Application no: 22/00638/DISC

Location: Begbroke Science Park, Begbroke Hill, Begbroke, Oxfordshire, OX5 1PF

Oxfordshire County Council **Object** to the discharge of Condition 18 'Turning area specification'

Oxford County Council **Object** to the discharge of Condition 20 'Construction Management Plan.

TITLE: **Additional 7 parking Spaces**

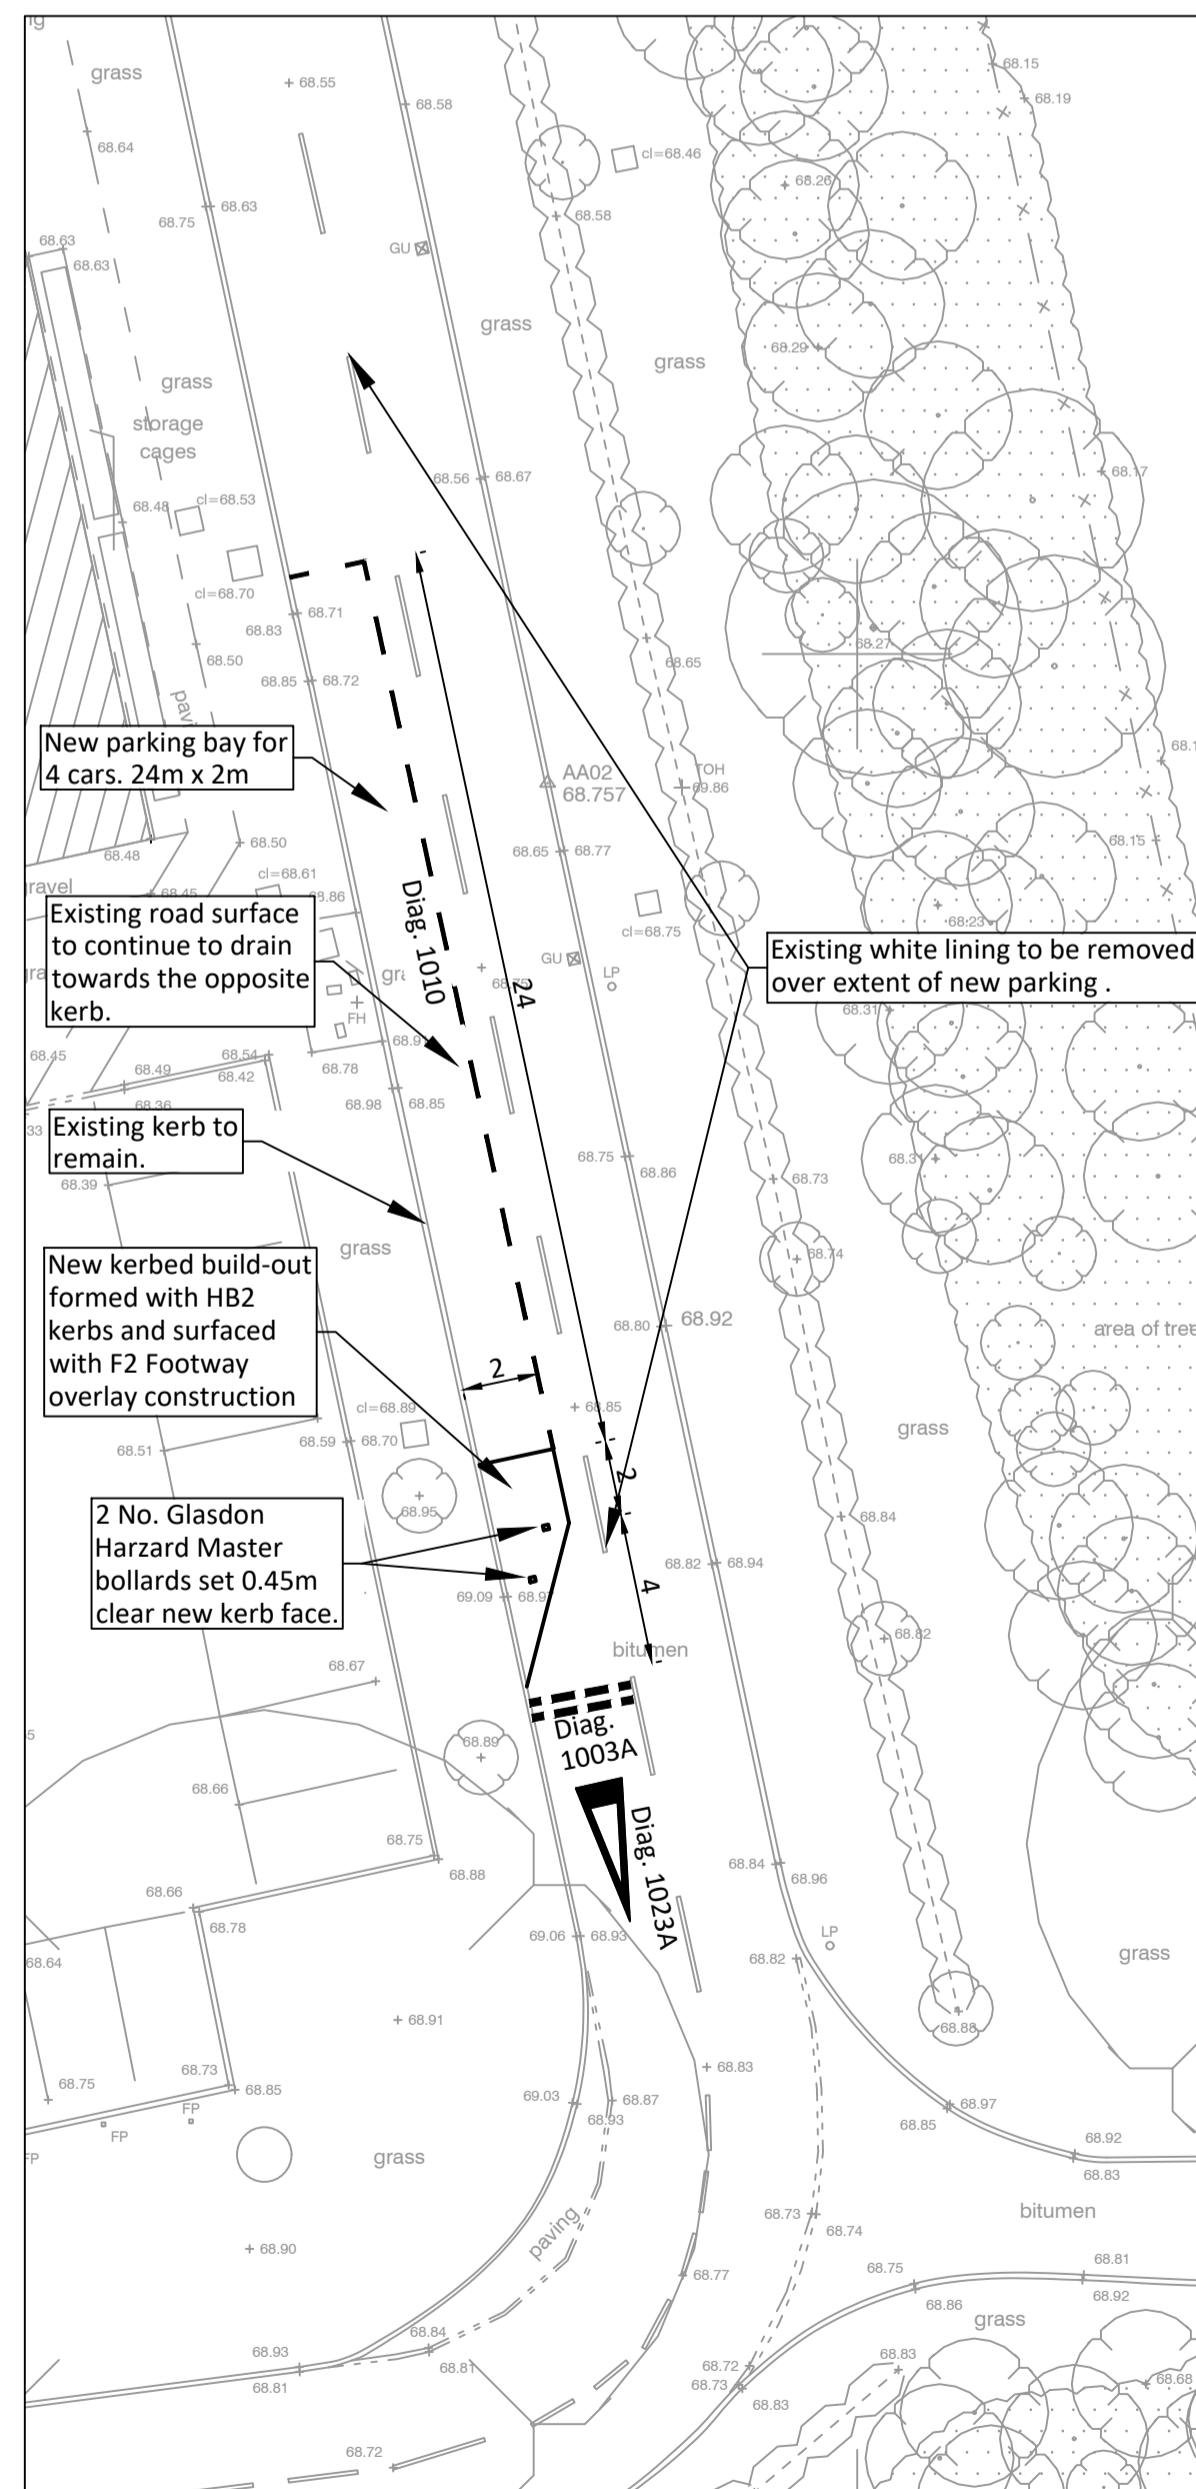
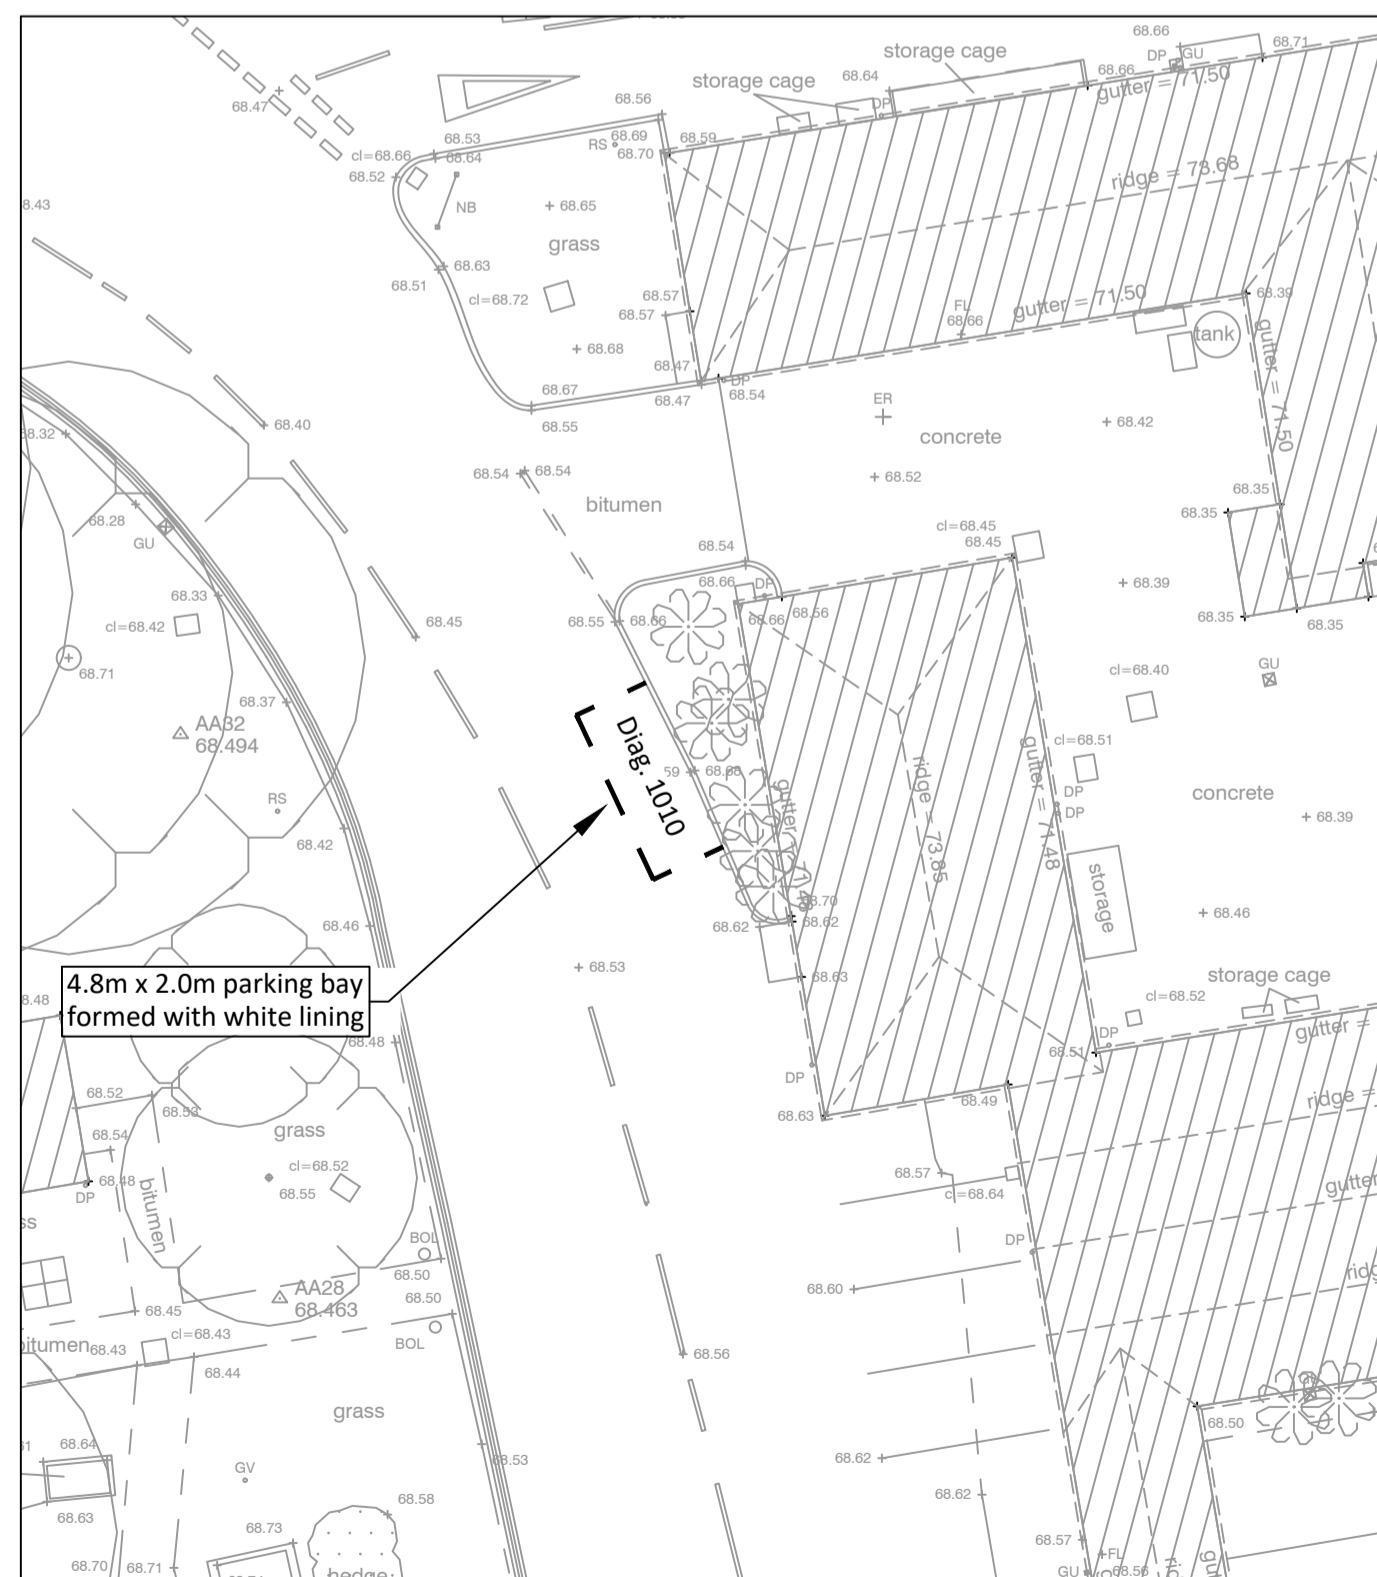
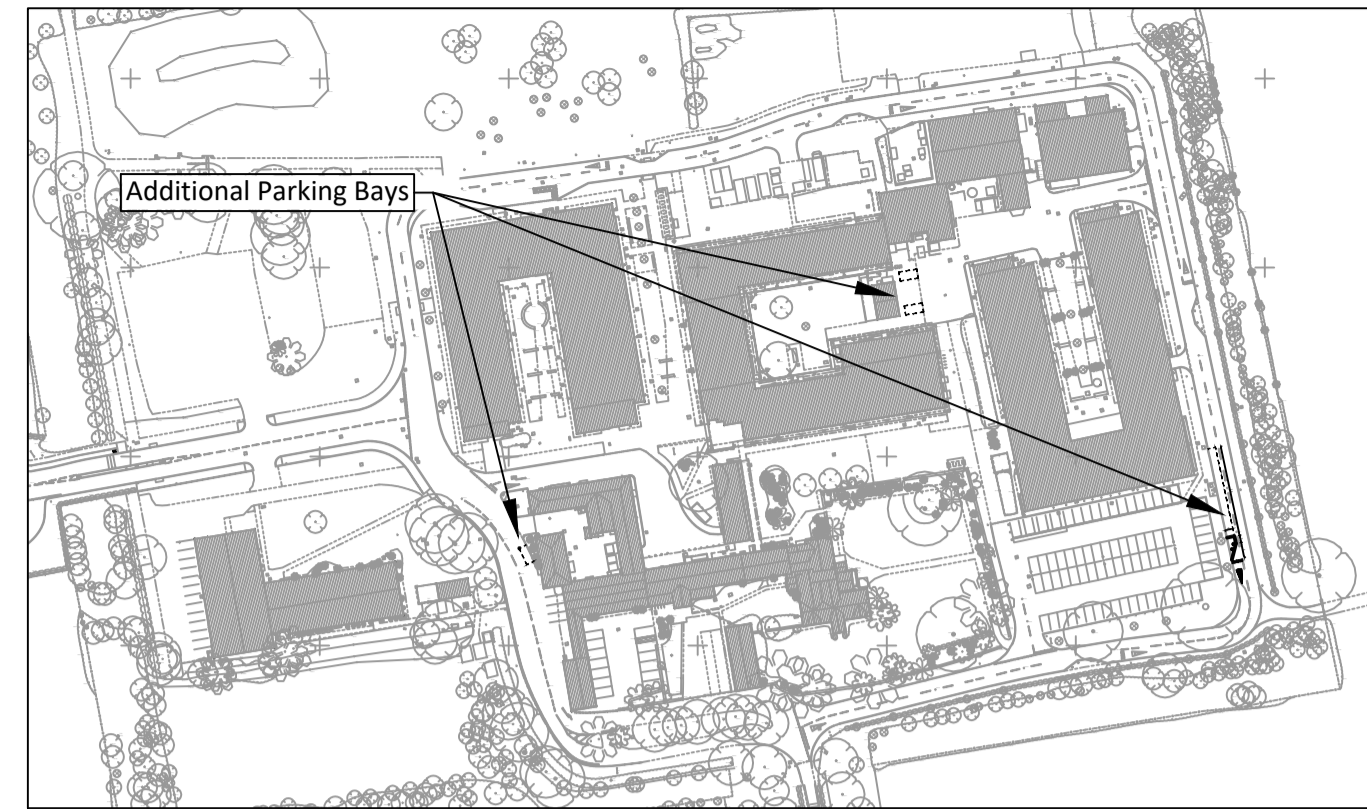
- Not all vehicle spaces within the site including those that are situated within the car park have the required 6.0m manoeuvrability.
- Number of Spaces pictured within Appendix 1 does not match those detailed within the technical statement.

The OCC guidance for space between vehicle parking bays measures at 6.0m so that cars can 'swing' into spaces. Many of the spaces within the following car parks including the 'New Surfaced Car Park, OGT/IAT, Units 5 & 6 do not have this space. This ultimately jeopardises the condition as it may restrict vehicles' ability to reverse and leave the car park forwards as well as general manoeuvrability and convenience. This is emphasised by the exclusion of a turning area, this will need to be amended before the condition can be discharged.

The Parking proposal states that the amount of vehicle parking spaces when including disabled spaces should total to 414. When including the unallocated, parallel parking bays, it totals to 418. It must be confirmed, before discharging this condition, the exact number of spaces that are within this development.
